HERTFORDSHIRE HOST AUTHORITIES' COMMENTS ON ANY FURTHER INFORMATION / SUBMISSIONS RECEIVED BY DEADLINE 4

London Luton Airport Expansion

OUR REF. NO. **TR020001**

DATE: **NOVEMBER 2023**

Figure 15 Site 128 Classified Counts – Vehicle Split

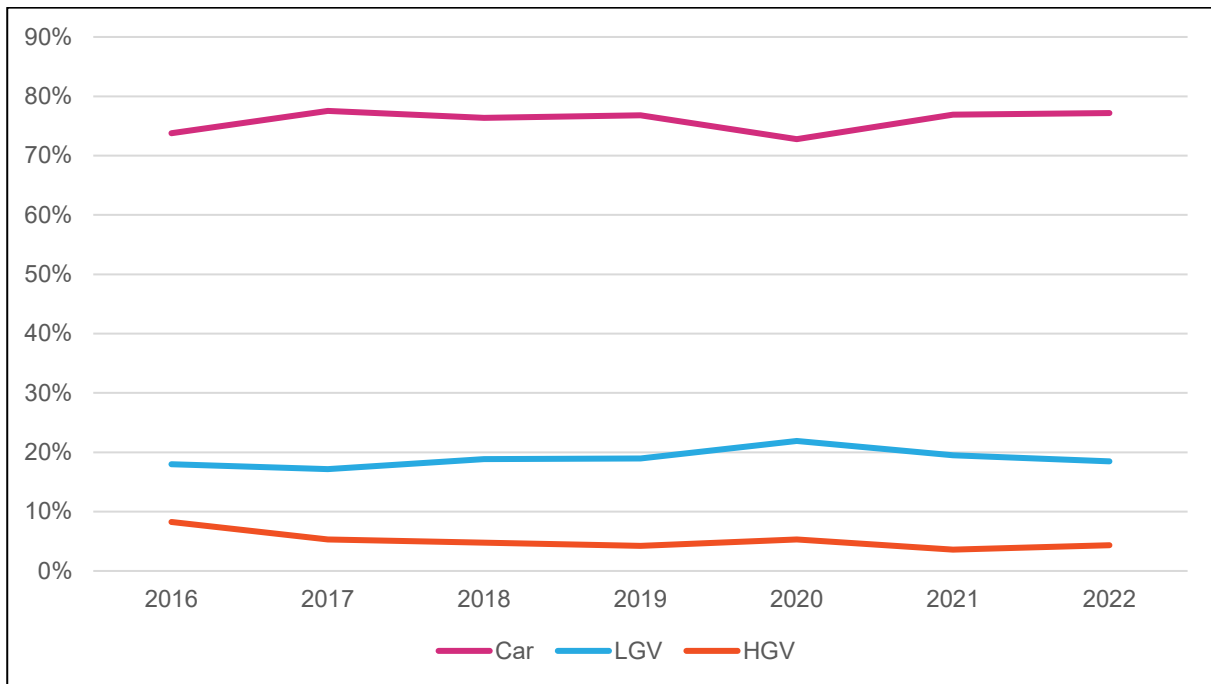
Figure 15	Traffic and Transport	Covid-19 Modelling	The Applicant should confirm what time period is represented in Figure 15. The Applicant should provide changes in traffic flow volumes (and not percentages) in AM, IP and PM Cars, HGV's and LGV's where the data exists as this will shows the changes in different vehicle type volumes.
Figure 16	Traffic and Transport	Covid-19 Modelling	The Applicant should confirm what time period is represented in Figure 16. The Applicant should provide changes in traffic flow volumes (and not percentages) in AM, IP and PM Cars, HGV's and LGV's where the data exists as this will shows the changes in different vehicle type volumes.
Figure 18	Traffic and Transport	Covid-19 Modelling	Site 371 sees a significant decrease in peak hour traffic post Covid-19. The Applicant should clarify whether they have investigated any other potential causes of this decrease, with the local authorities for example, to understand whether there is any other explanation for this reduction other than Covid-19.

Figure 20 Site 40 Two-Way Traffic by Peak

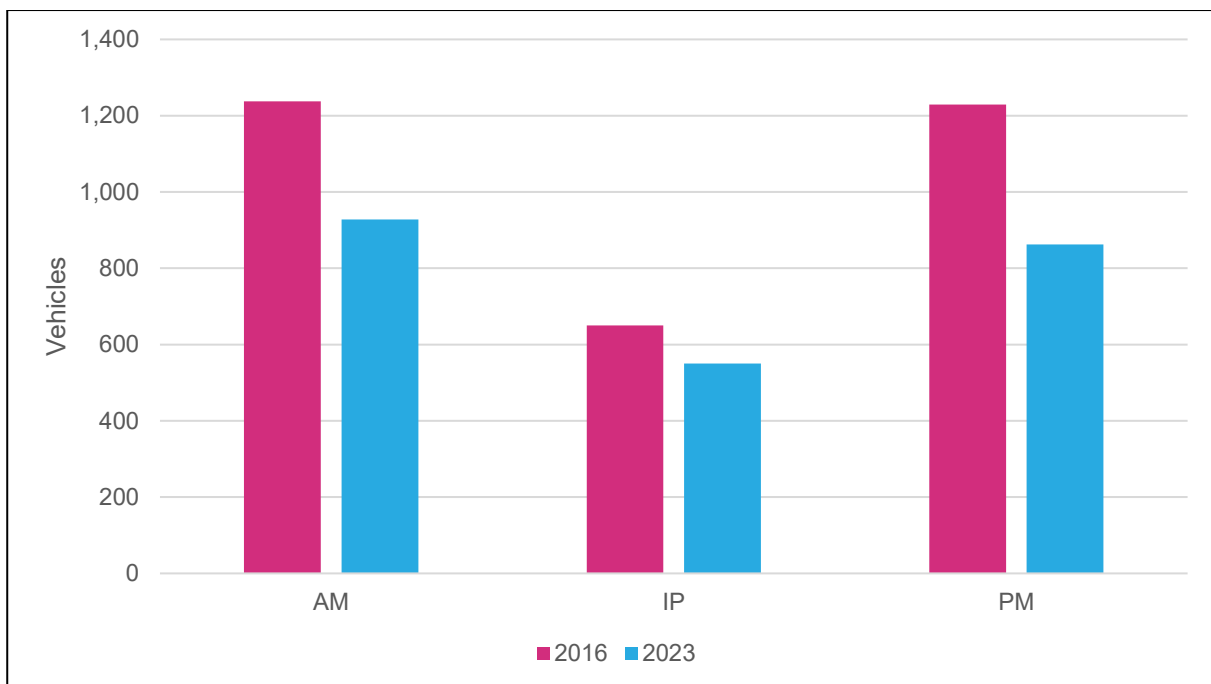
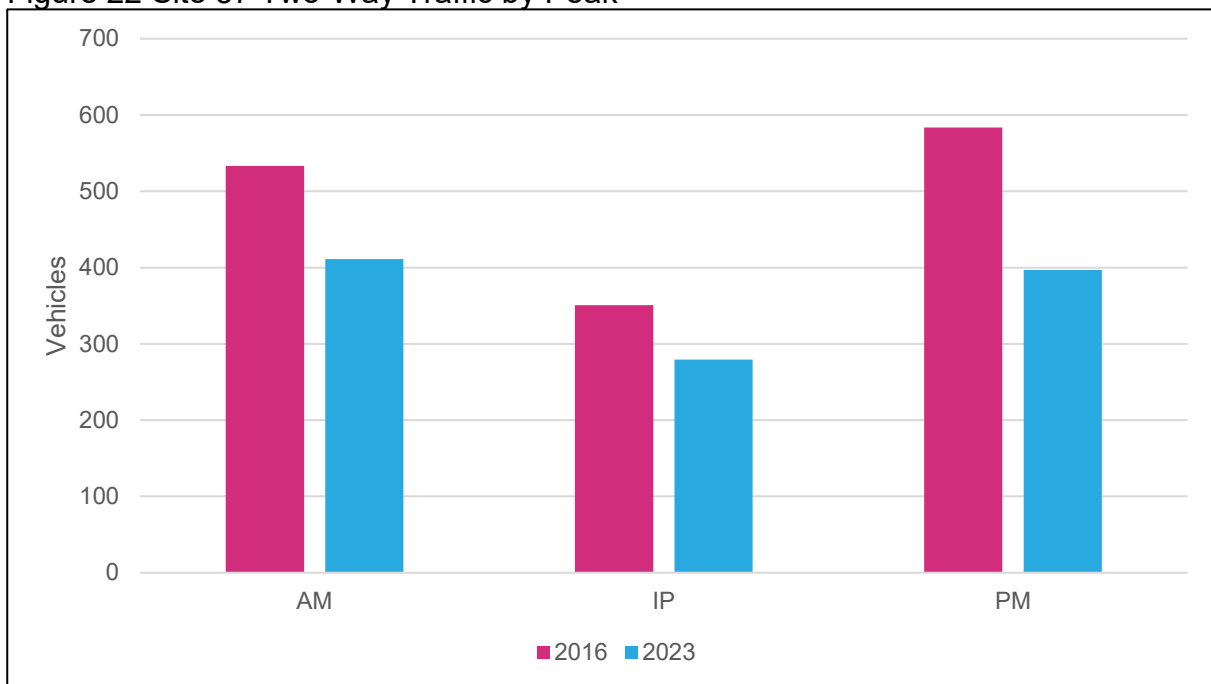
Figure 20 and 22	Traffic and Transport	Covid-19 Modelling	Sites 40 and 57 sees a significant decrease in peak hour traffic post Covid-19. The Applicant should clarify whether they have investigated any other potential causes of this decrease, with the local authorities for example, to understand whether there is any other explanation for this reduction other than Covid-19.
Chapter 3	Traffic and Transport	Covid-19 Modelling	The Applicant should provide some commentary on the changes in bus use in the study area between 2016 and 2023.
Chapter 3	Traffic and Transport	Covid-19 Modelling	The Applicant should provide some commentary on the changes in London Luton Airport use in the study area between 2016 and 2023.
Figure 32	Traffic and Transport	Covid-19 Modelling	The Applicant should confirm whether this graph is showing National or Local Growth Productions by mode.

Figure 33 Growth in trip productions through time NTEM 7.2 and NTEM 8

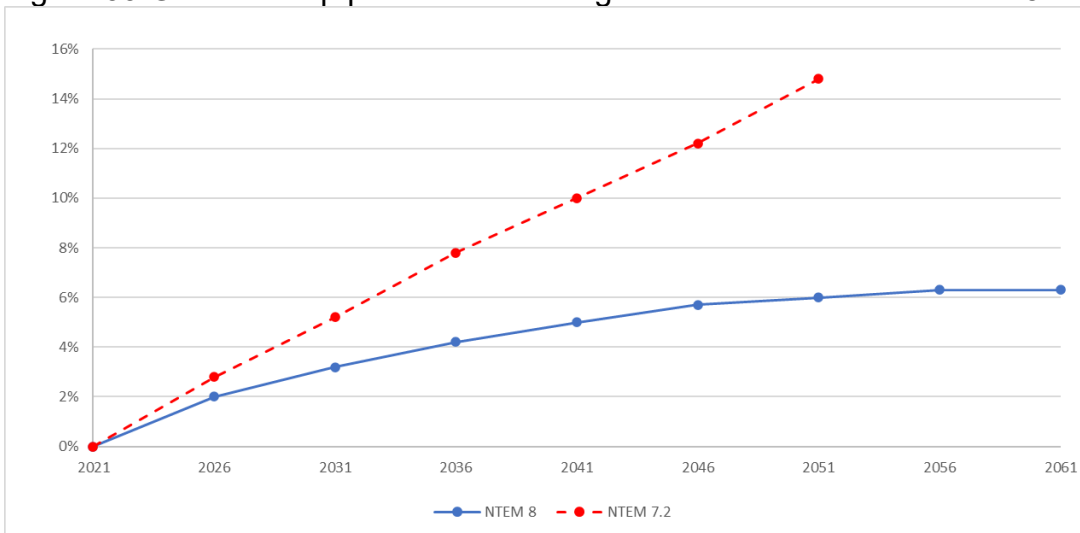
Reference	Topic	Matters Raised	Hertfordshire Host Authorities Comment
Figure 33	Traffic and Transport	Covid-19 Modelling	The Applicant should confirm whether this graph is showing National or Local Growth Productions.
Figure 34	Traffic and Transport	Covid-19 Modelling	The Applicant should confirm whether this graph is showing National or Local Growth Productions.
